Re: Major Projects – New Request for Advice - Yennora Liquid Waste Treatment Plant (SSD-10407)

Please find below comments from Cumberland Council below:

Figure 2.1. Swept paths for heavy vehicles accessing the site at 14- 16 Kiora Crescent, Yennora. NSW Surveys PTY LTD, 8/11/19.

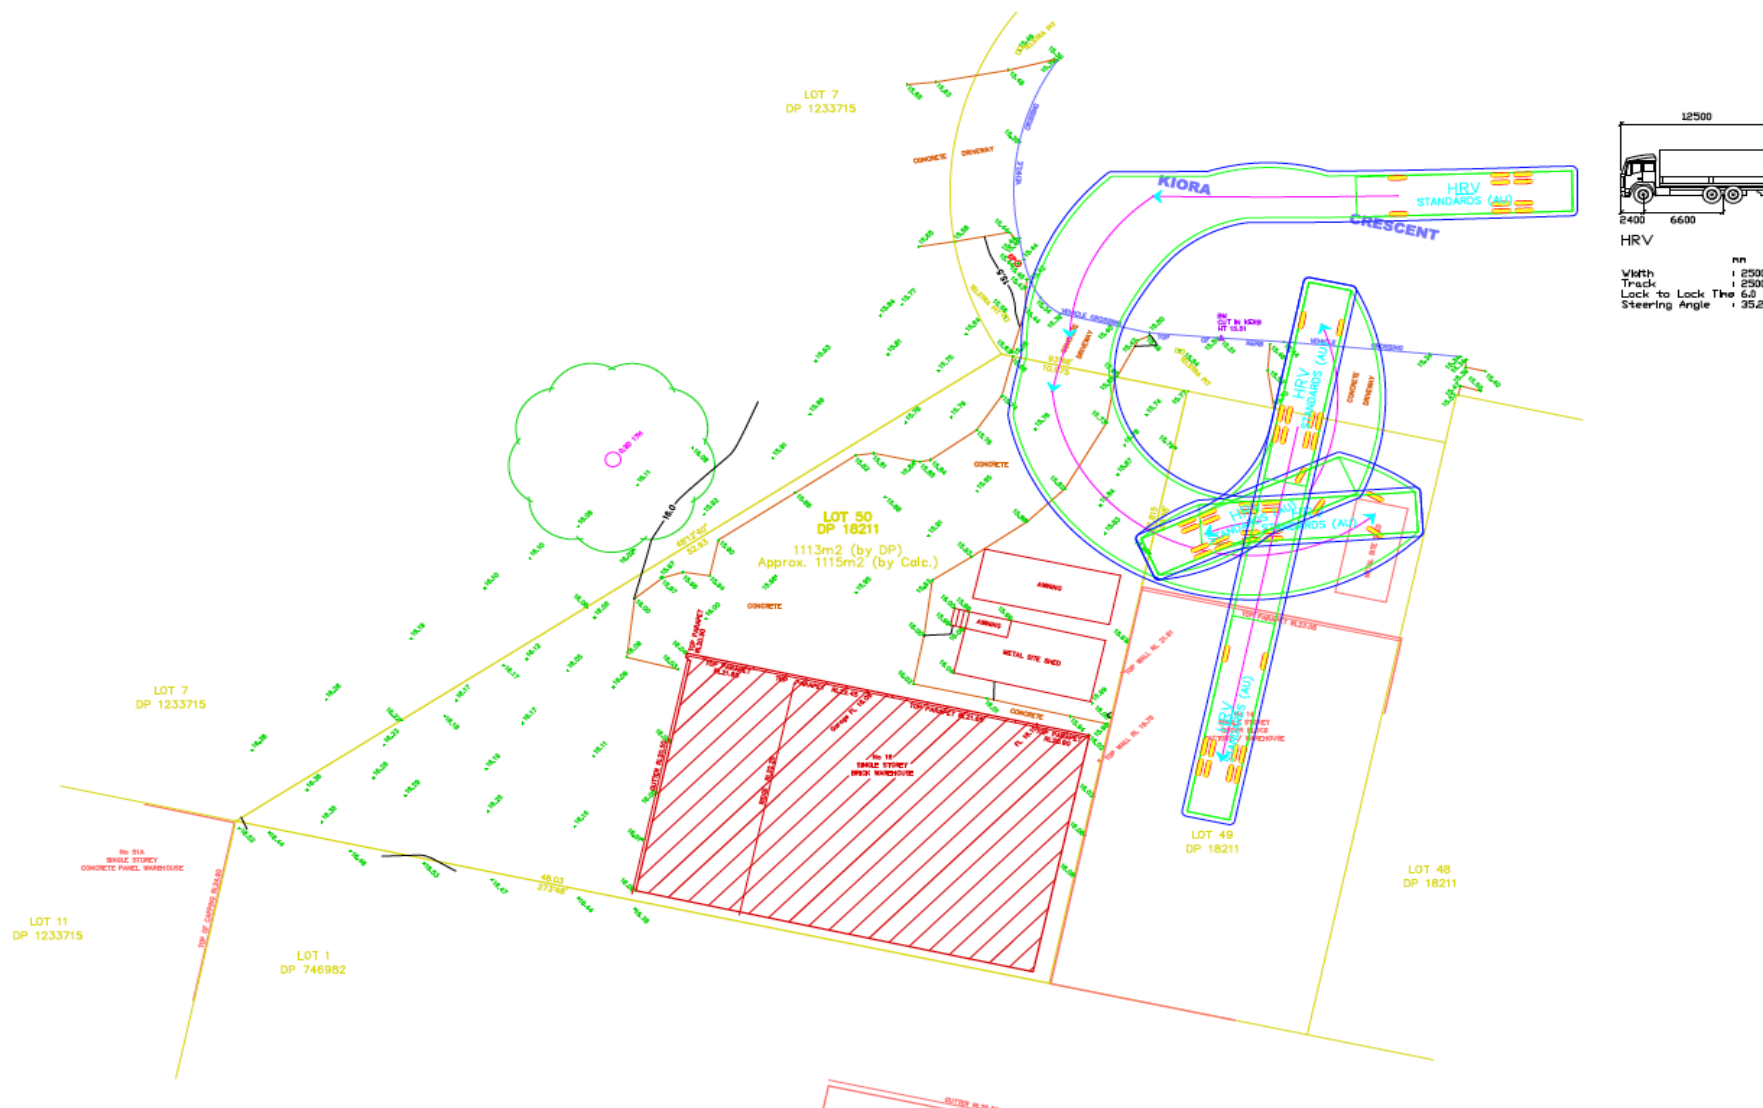
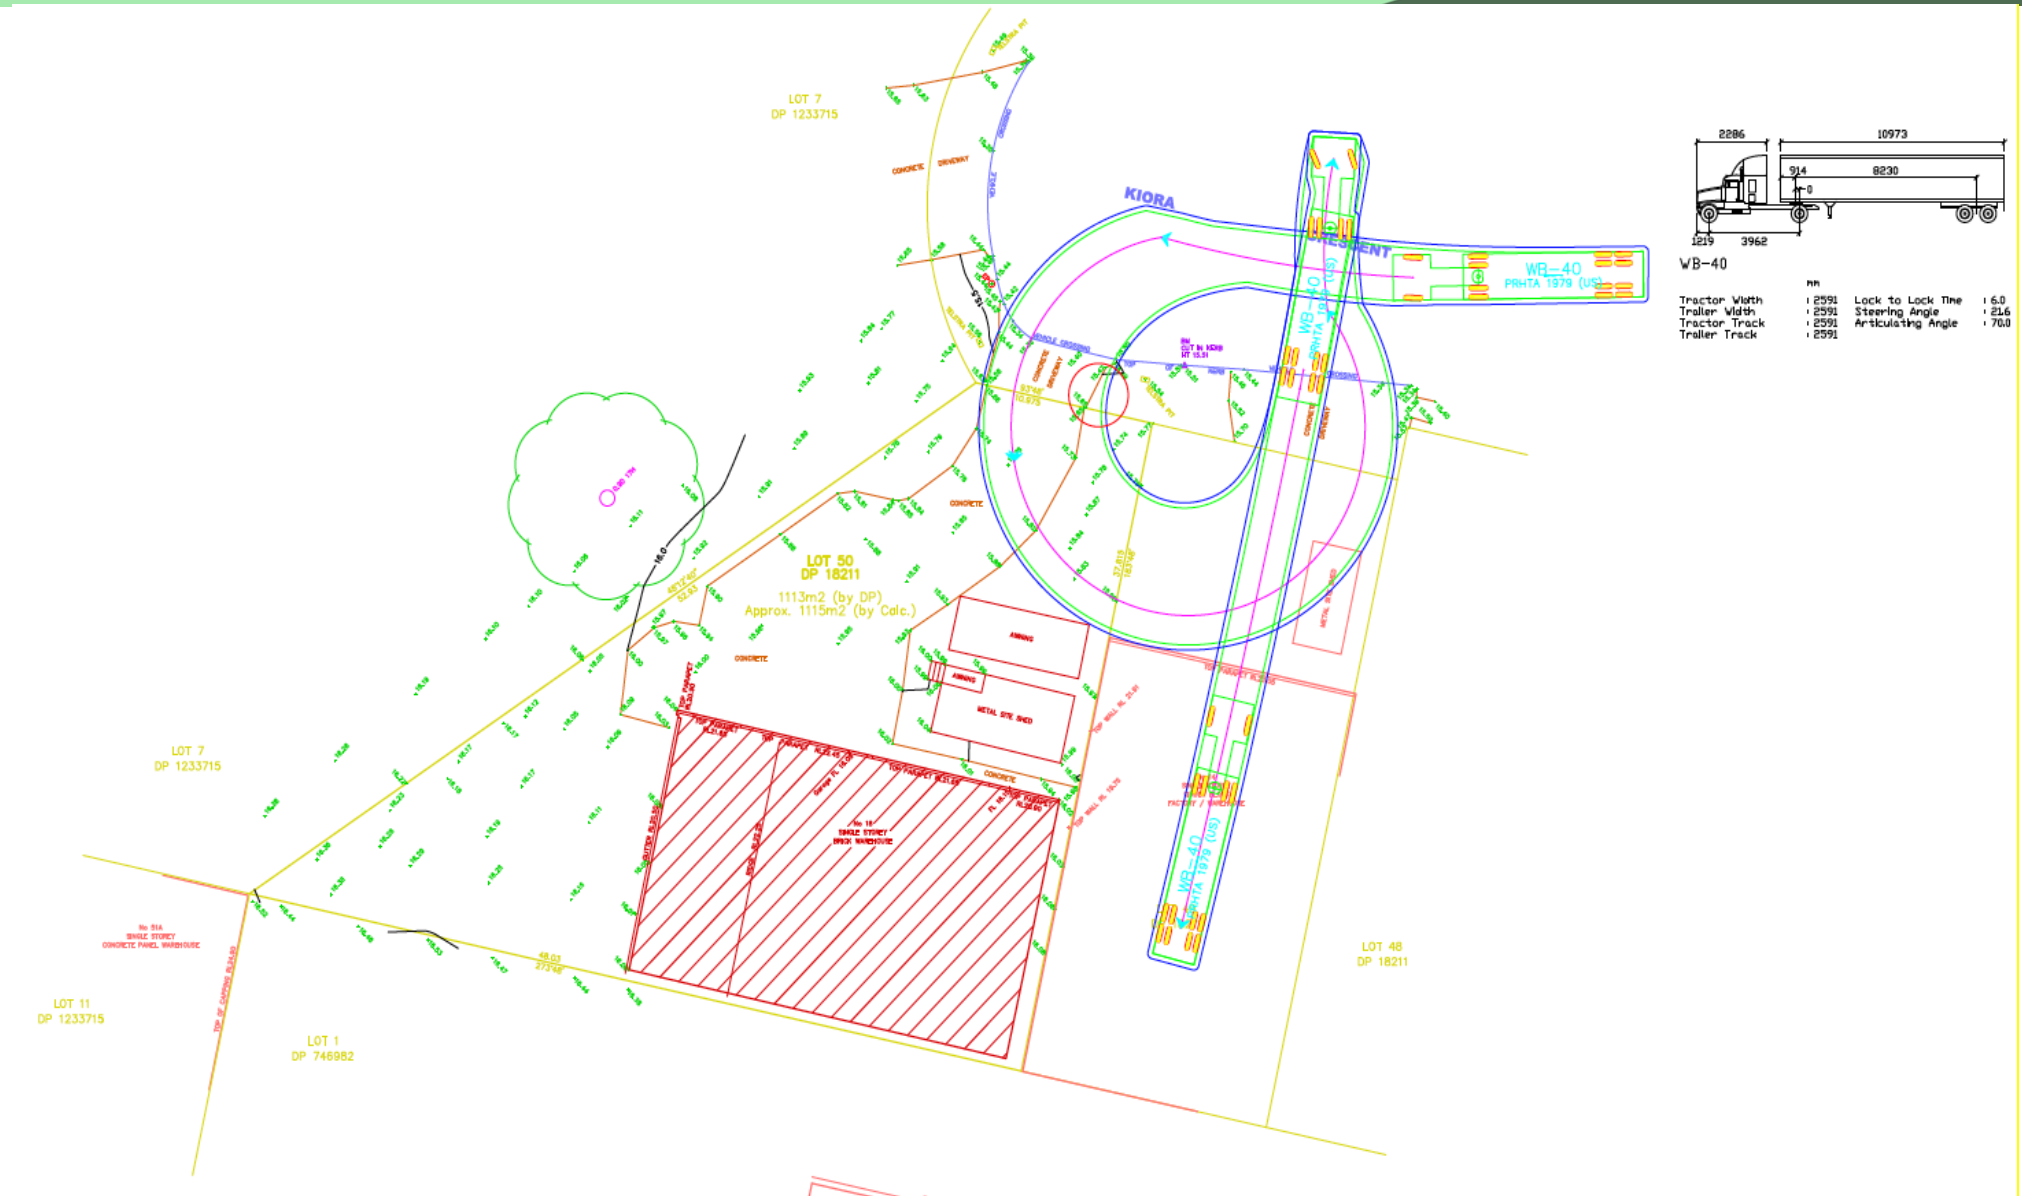
Proposed swept path analysis is not acceptable. The swept path analysis shows that the turning path encroaches into Council footpath and nature strip.

Reverse manoeuvring in Council's land is not acceptable. It will compromise the safety. Vehicles should enter and leave the site in a forward direction.

Proposed 4 point turn truck manoeuvring movement is not acceptable. Manoeuvring shall be limited to three point turn.

Truck swept path interferes with the car parking space.
